ACADEMY VILLAGE FILING NO. 3  
 GRADING & EROSION CONTROL PLAN  
 SHEET 2 OF 4  
 JOB NO. 25123.00

ACADEMY VILLAGE FILING NO. 3  
UTILITY SERVICE PLAN  
SHEET 4 OF 4  
JOB NO. 25123.00

# Markup Summary

ACADEMY VILLAGE FILING NO. 3  
**GRADING & EROSION CONTROL PLAN**  
SHEET 2 OF 6  
JOB NO. 25123.00

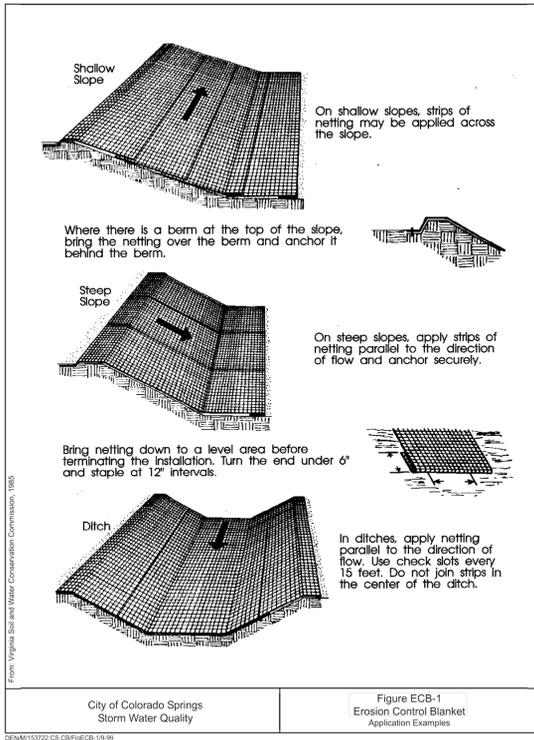
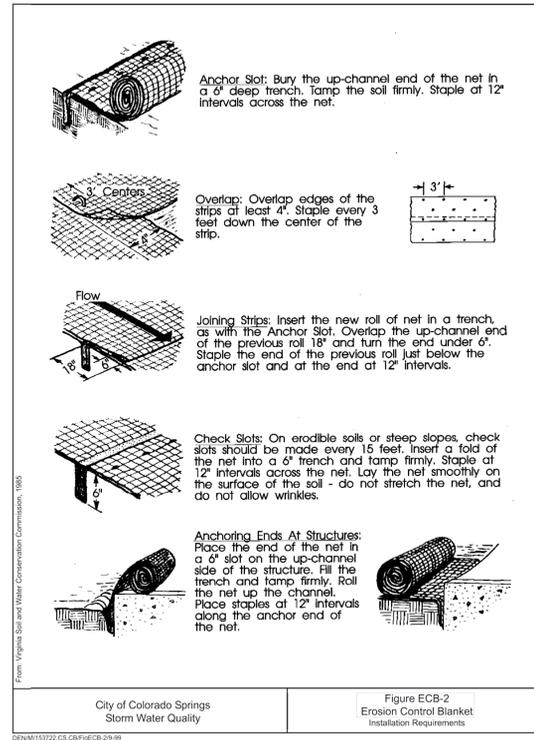
Provide "LOD" linetype/symbol in legend

ACADEMY VILLAGE FILING NO. 3  
UTILITY SERVICE PLAN

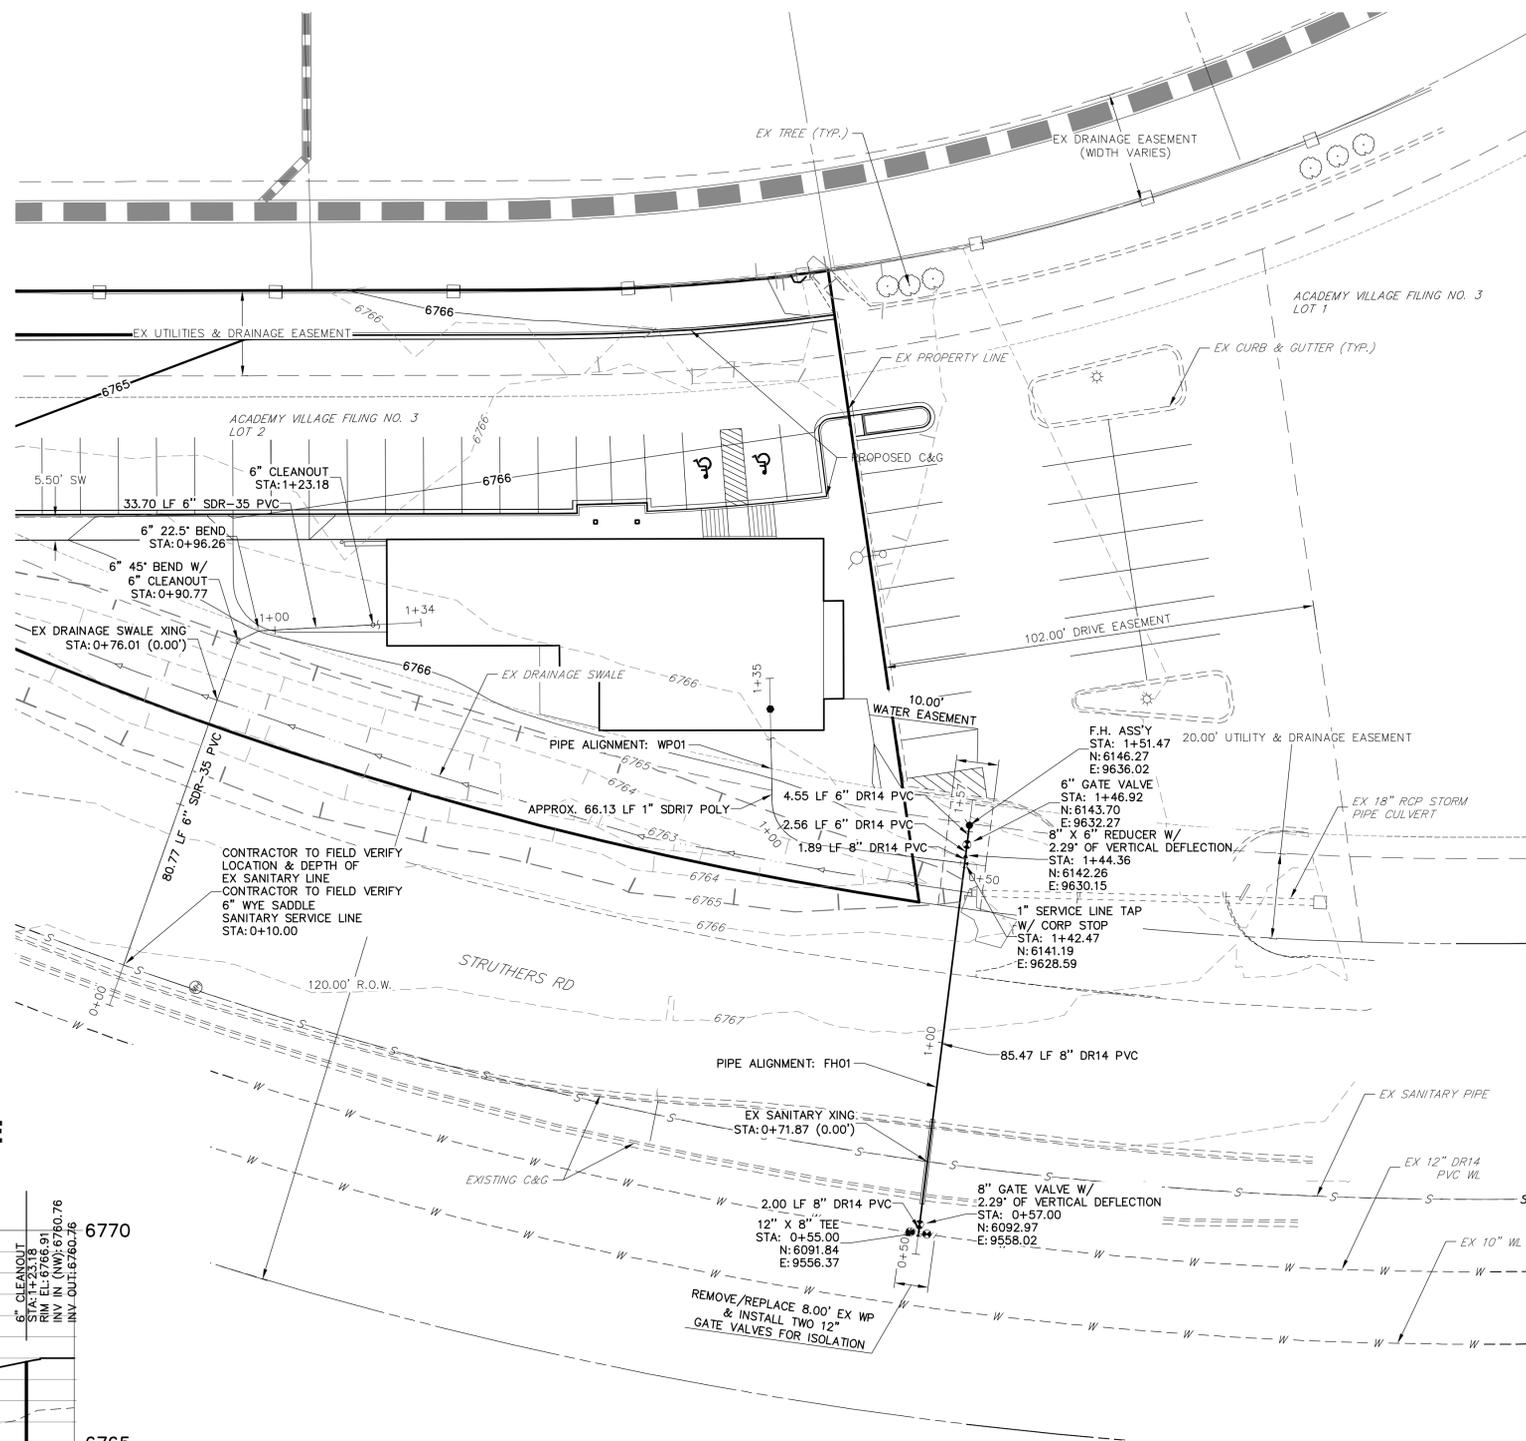
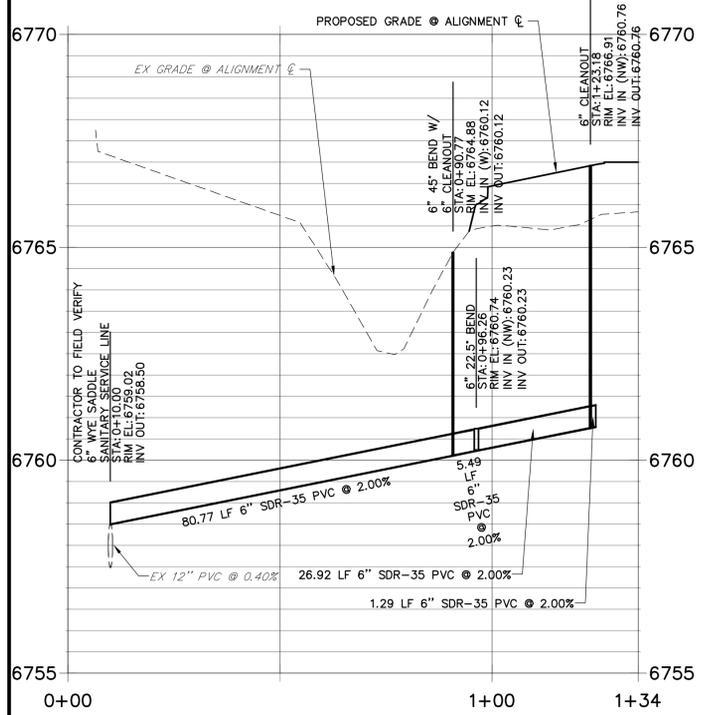
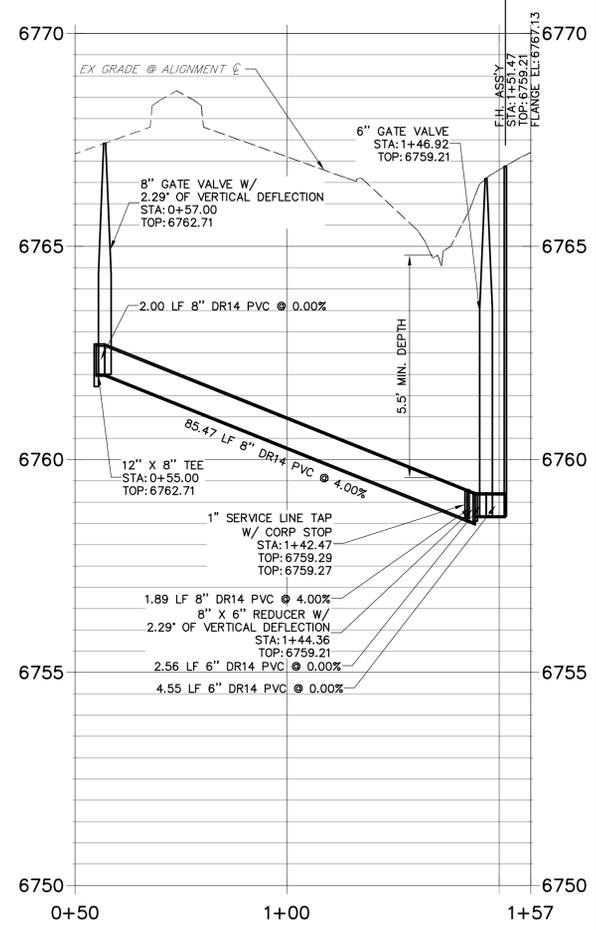
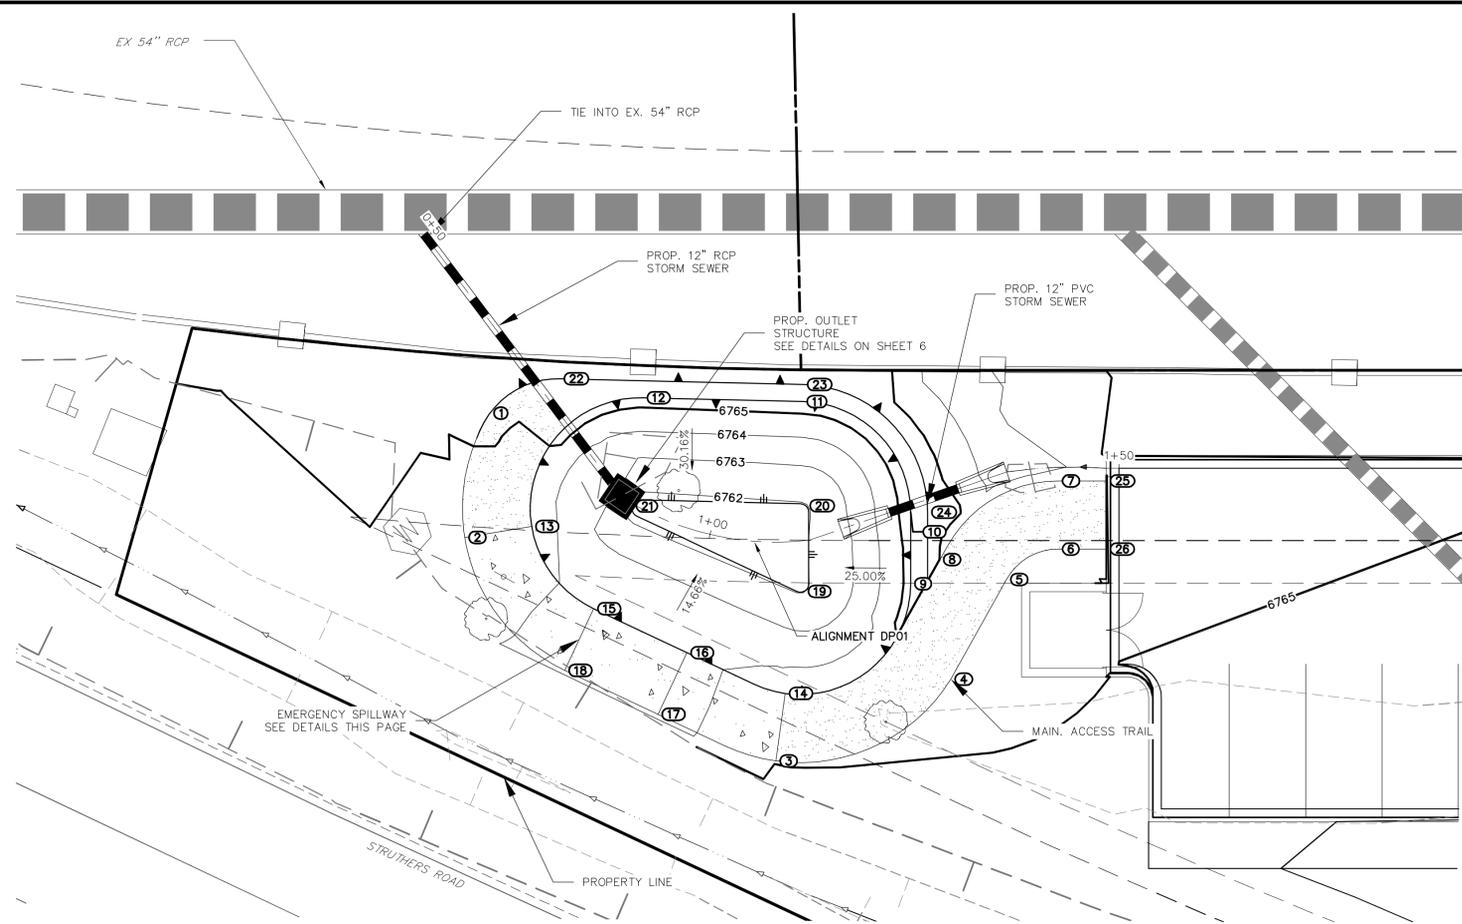
Move GEC signature blocks to cover sheet.  
Provide utility District signature blocks on this sheet.
